Application for a non-material amendment following a grant of planning permission.
Town and Country Planning Act 1990

Rear extension to north elevation

Move west facing wall away from boundary

Item#	Quantity	Title/Name, designation, material, dimension etc		Article No./Reference
Designed by	Checked by	Approved by - date	Filename	Date
65 Van Gogh Place	XXX			July 2017
Proposed Rear Extension				Scale
				1:50
				02
				Edition
				0
				Sheet
				1/1

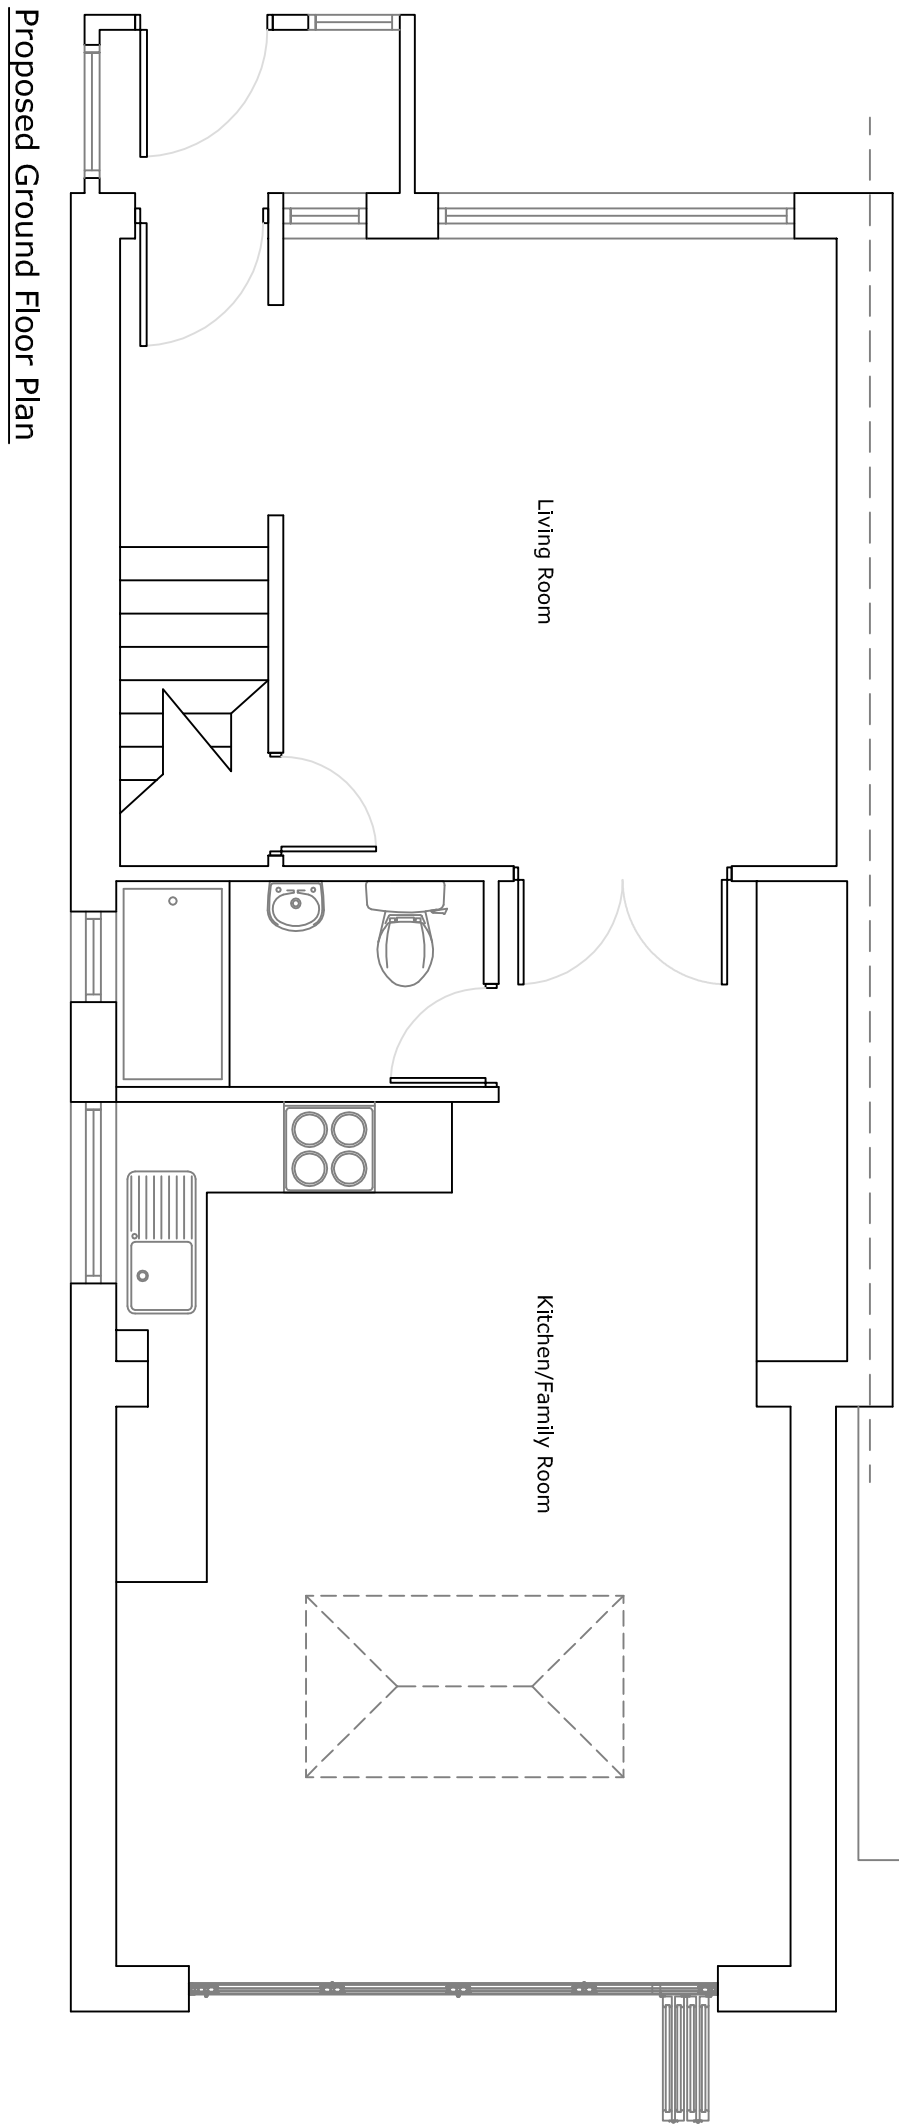
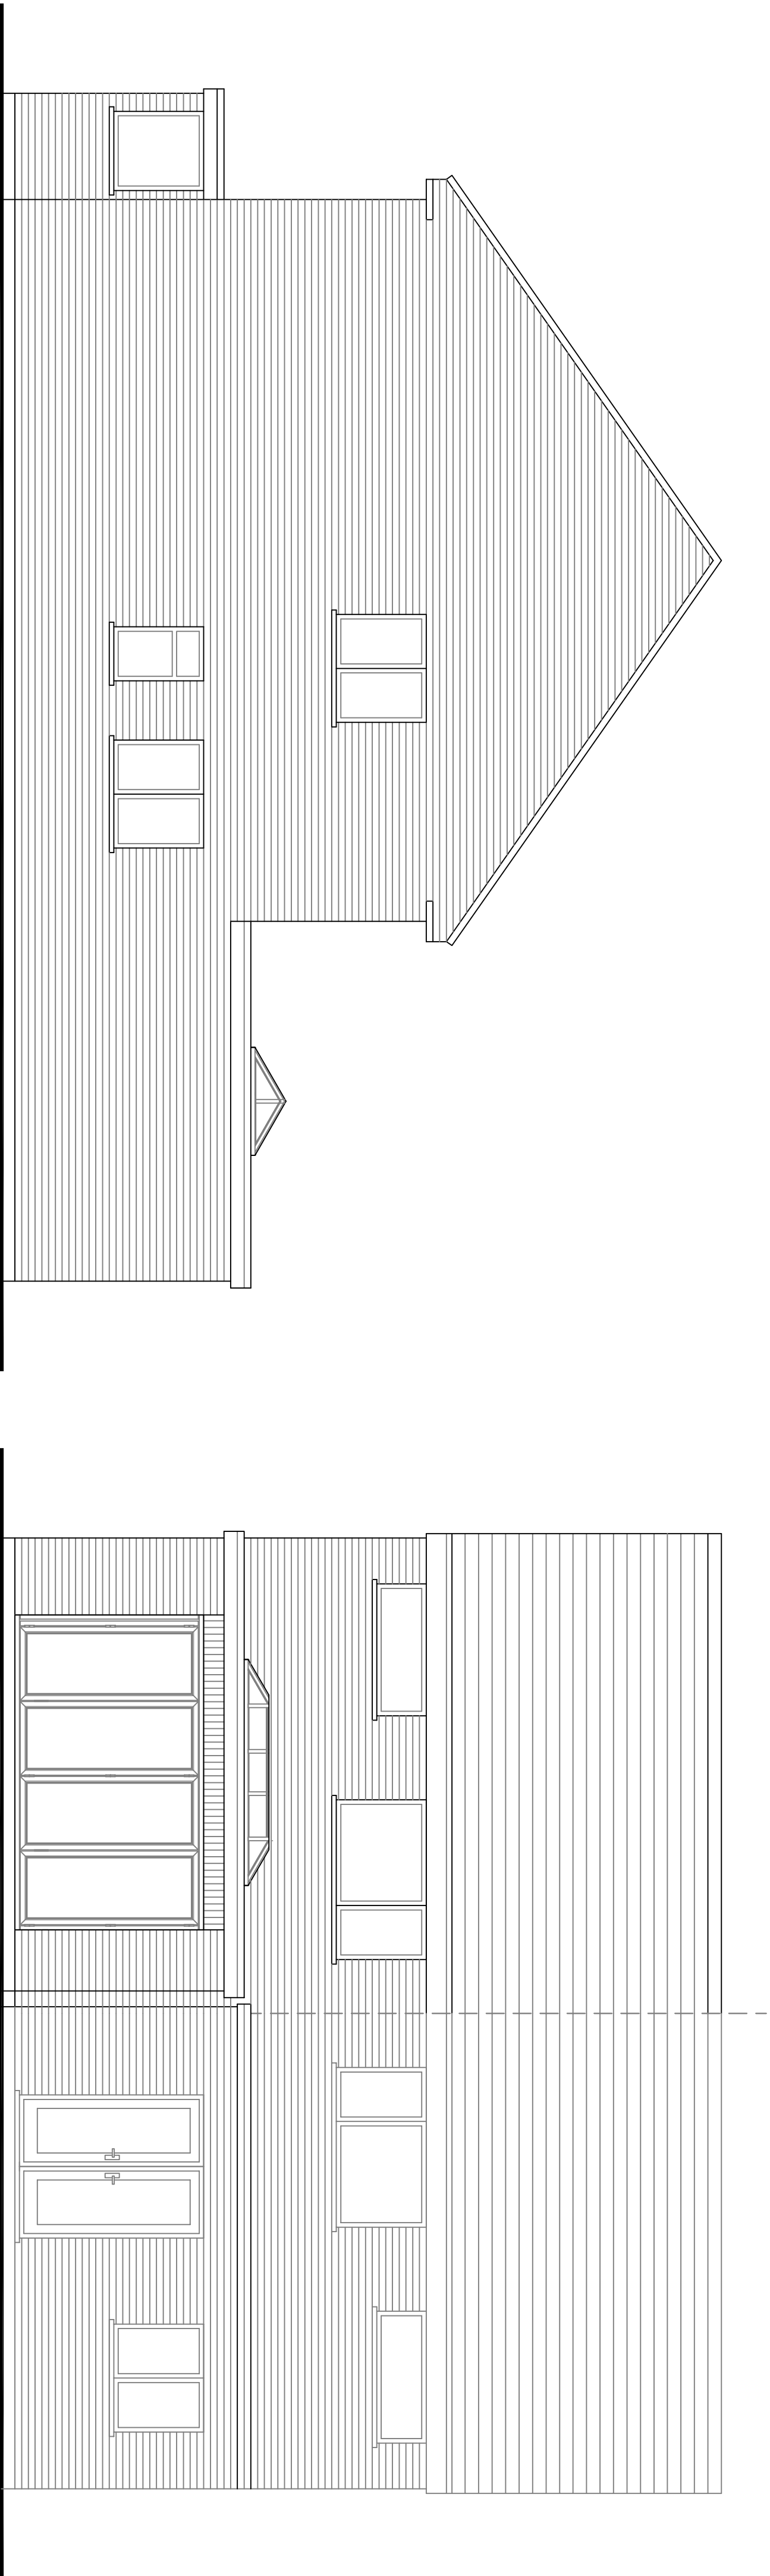
for ease of roof maintenance
